Our Case Number: ABP-314724-22

Re: Railway (Metrolink - Estuary to Charlemont via Dublin Airport) Order [2022]
Metrolink. Estuary through Swords, Dublin Airport, Ballymun, Glasnevin and City Centre to Charlemont, Co. Dublin

MetroLink Railway Order Submission

Re: NA29N.314724 Estuary through Swords, Dublin Airport, Ballymun, Glasnevin and City Centre to Charlemont, Co. Dublin

Drawing Title	METROLINK - STRUCTURES DUBLIN AIRPORT STATION PLATFORM & UNDER PLATFORM LEVEL		Drawing Status	S0
Drawing N°	ML1-JAI-SRD-ROUT_XX-DR-Y-02024	Plan Drawing N°	ML-ST 302 C-D4	
Scales Original Size A1	1 : 250		Sheet 4 of 6

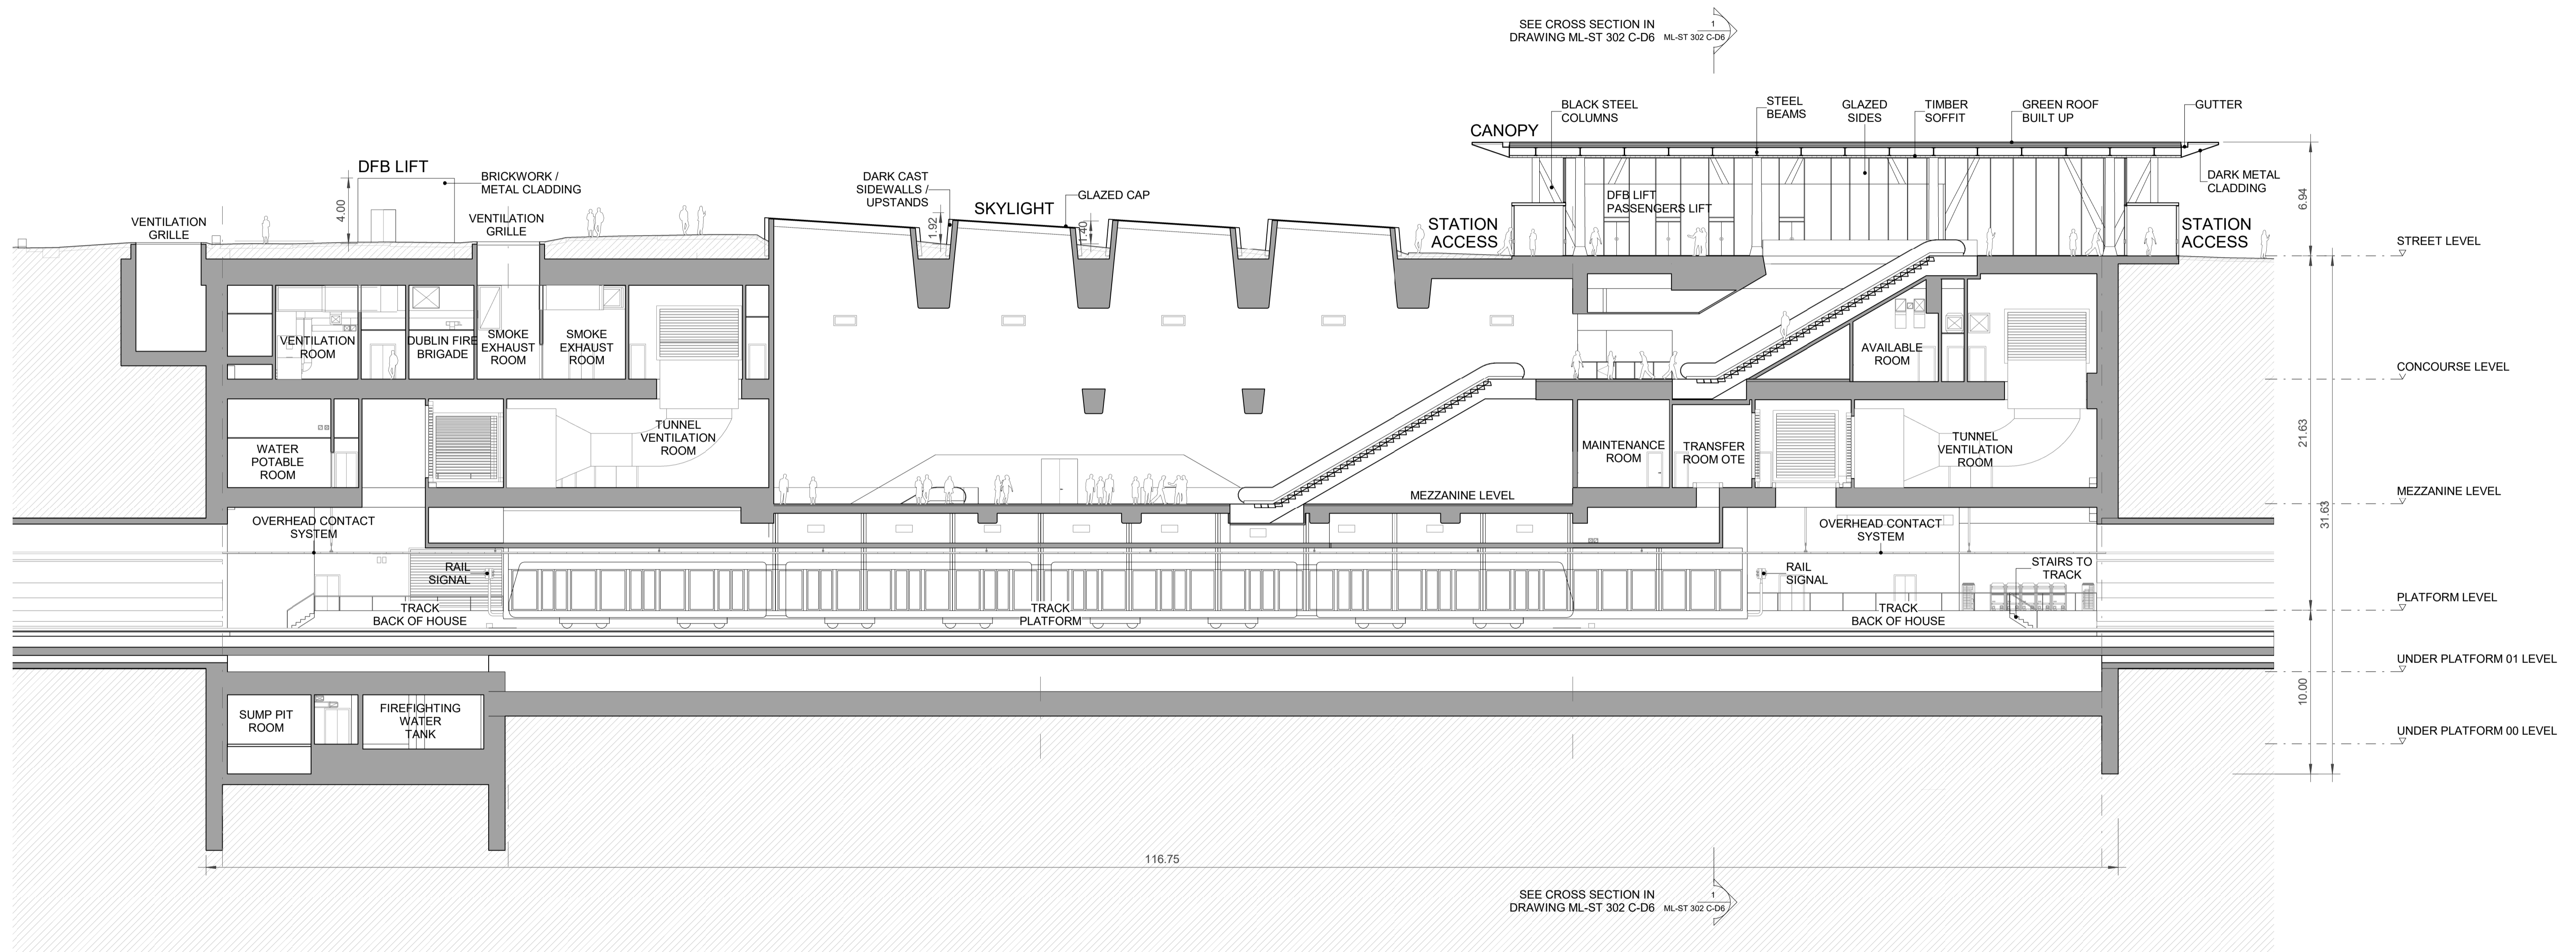
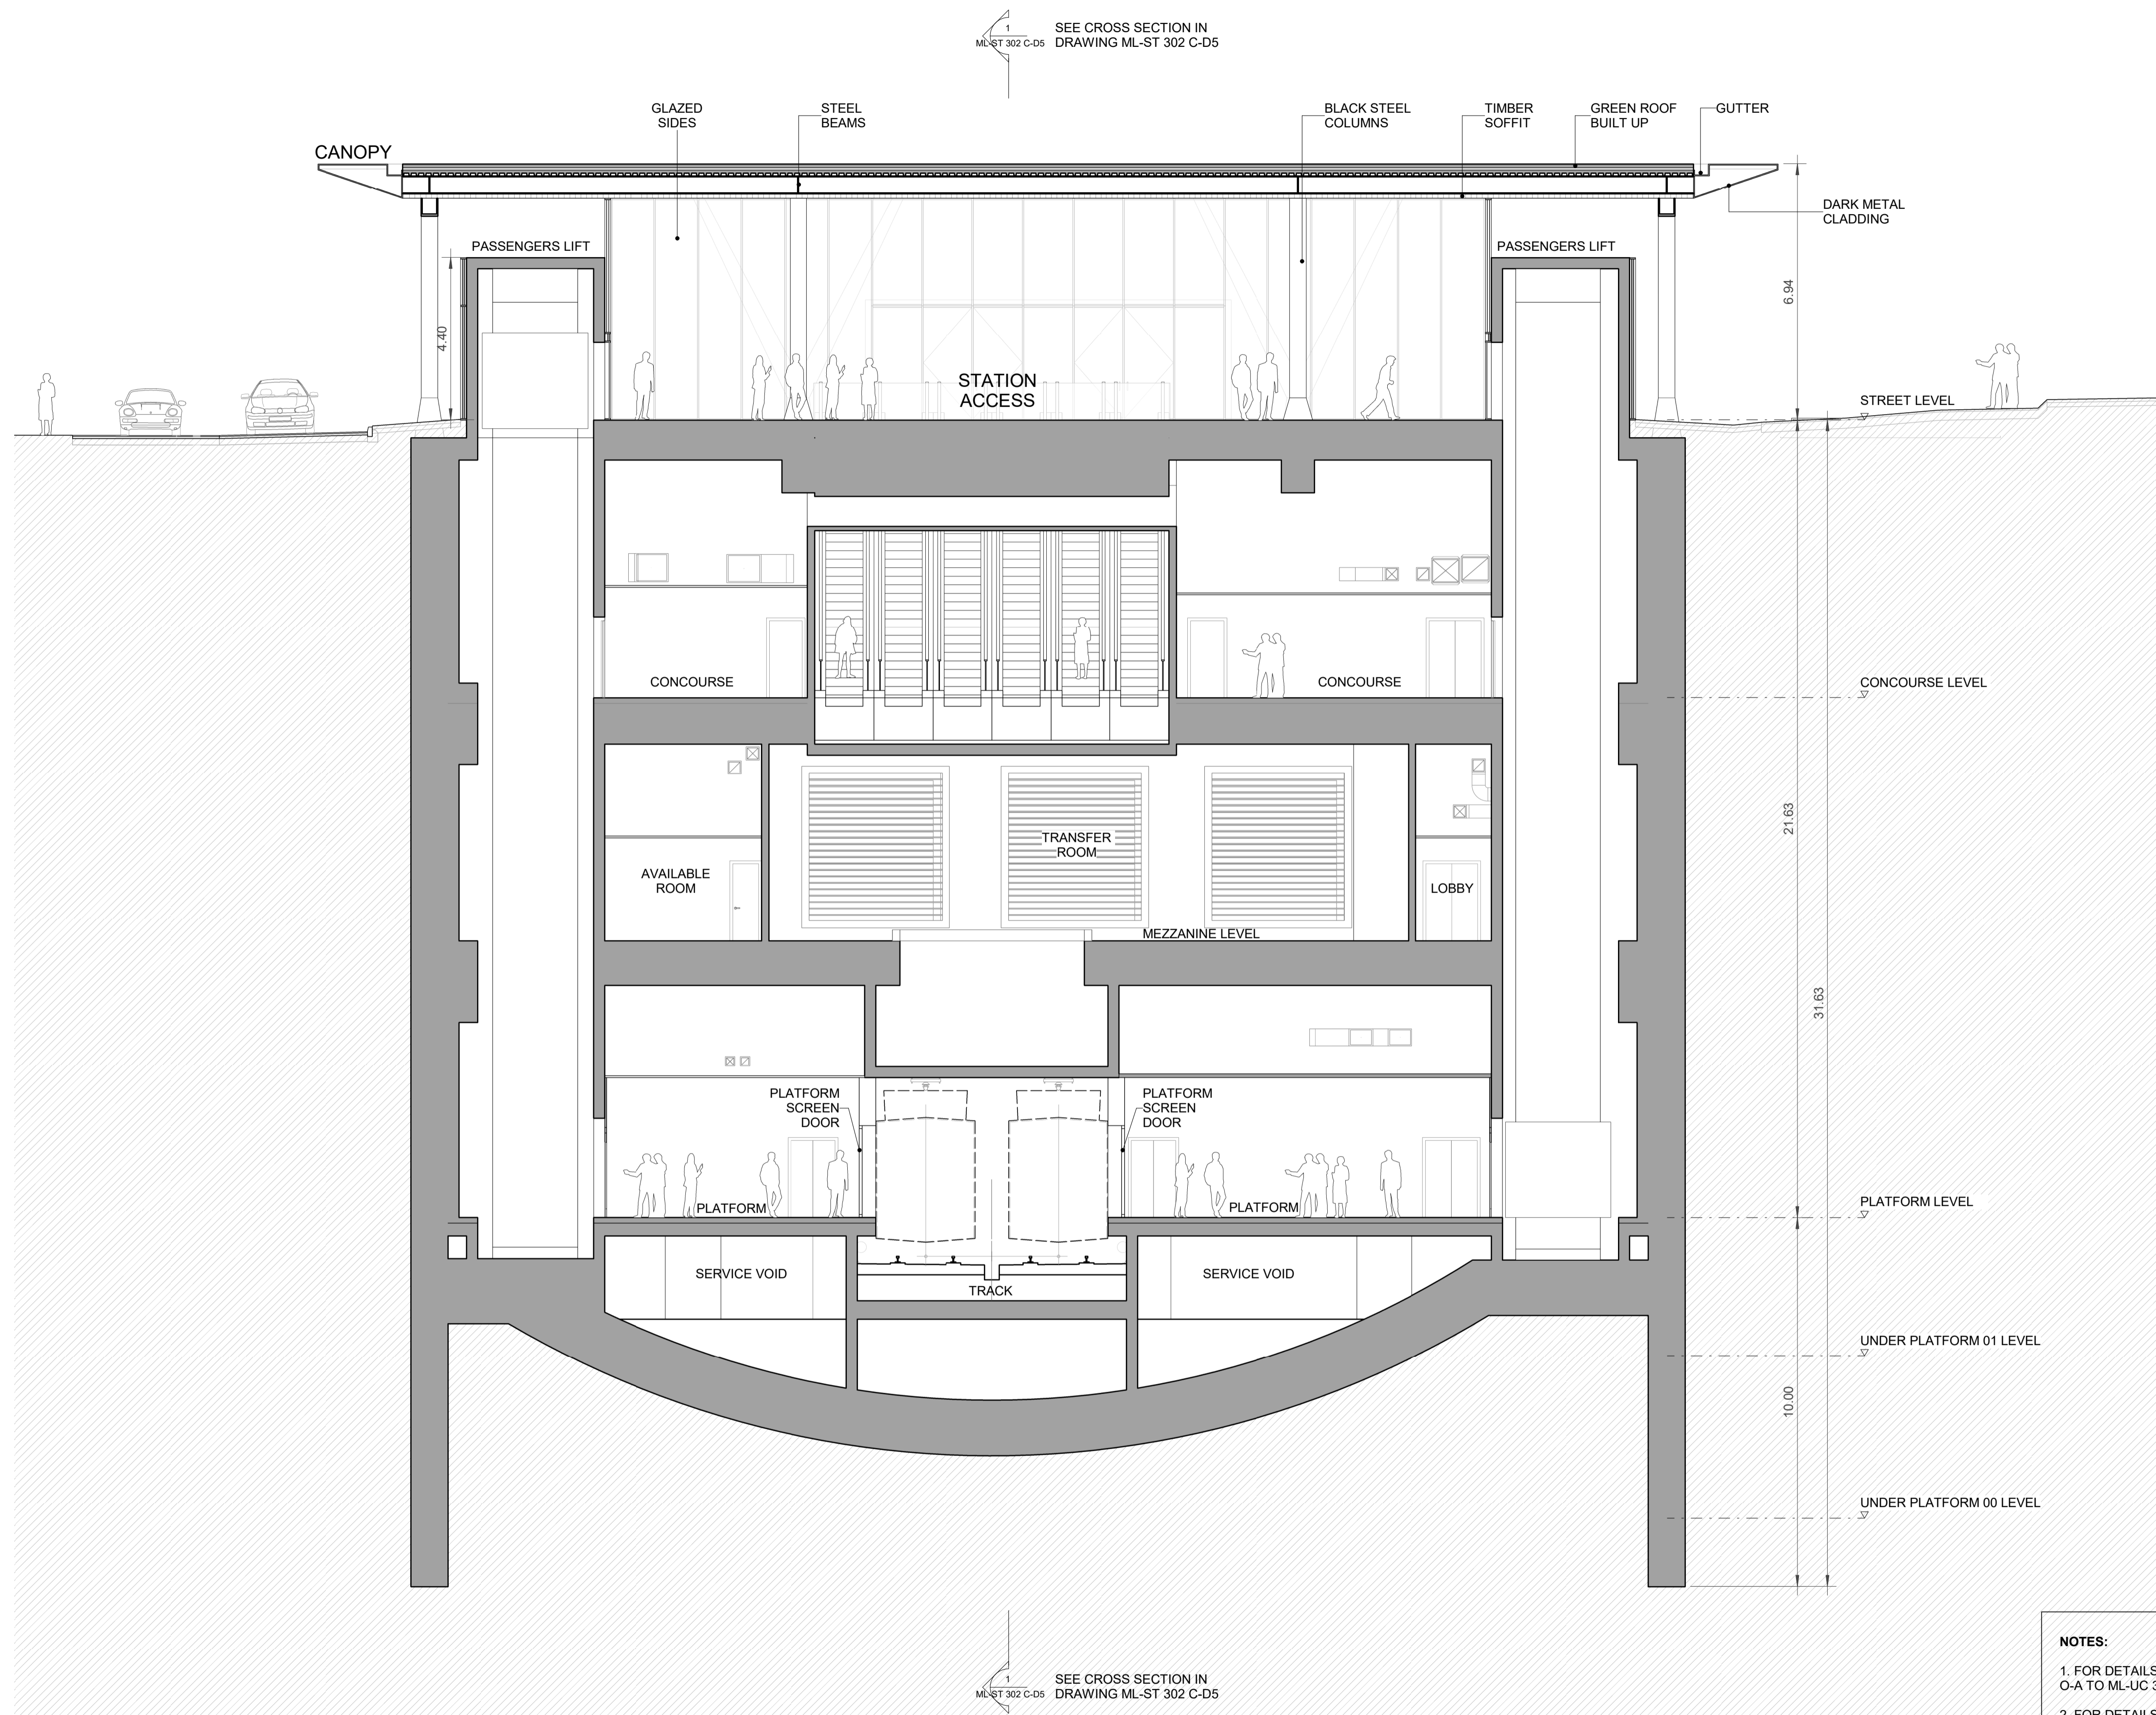
daa request the Metrolink station is designed to accommodate an elevated pedestrian walkway. This will ensure there is no impact on the safe and efficient operation of our internal roads which may be impeded by the number and frequency of the crossings.

Alternatives were considered to facilitate safe and efficient pedestrian movement. daa considered Elevated Pedestrian Connections to be a safer and preferable solution. When assessed all elevated alternatives offered a quality user experience that provides a safe, efficient, enjoyable and stress-free journey that encourages repeated use of MetroLink to access the airport. It is noted that a similar pedestrian walkway is provided at the proposed Estuary Station, connecting the MetroLink Station to the proposed car park. daa requests that the MetroLink station is designed to accommodate an elevated walkway.

daa request the station structure be designed, in agreement with the airport, such that it does not compromise future development above the station. is adapted to support a multistorey development.

daa requests that the station structure and retaining walls are designed and constructed to support future loads imposed by Dublin Airport development foundations that may be positioned near the MetroLink stations construction. It should be assumed the pavilion will rise to three levels and may incorporate a possible elevated Automated People Mover platform. It should also be assumed that the multi-storey car park will rise to a height of 110m AOD with the street level being a double height space designed to accommodate the bus/coach park, and thus will likely require increased open plan column spaces with increased foundation loading. daa request that the applicant indicates how the MetroLink station building structure can be adapted to support a multistorey development in line with the above objectives.
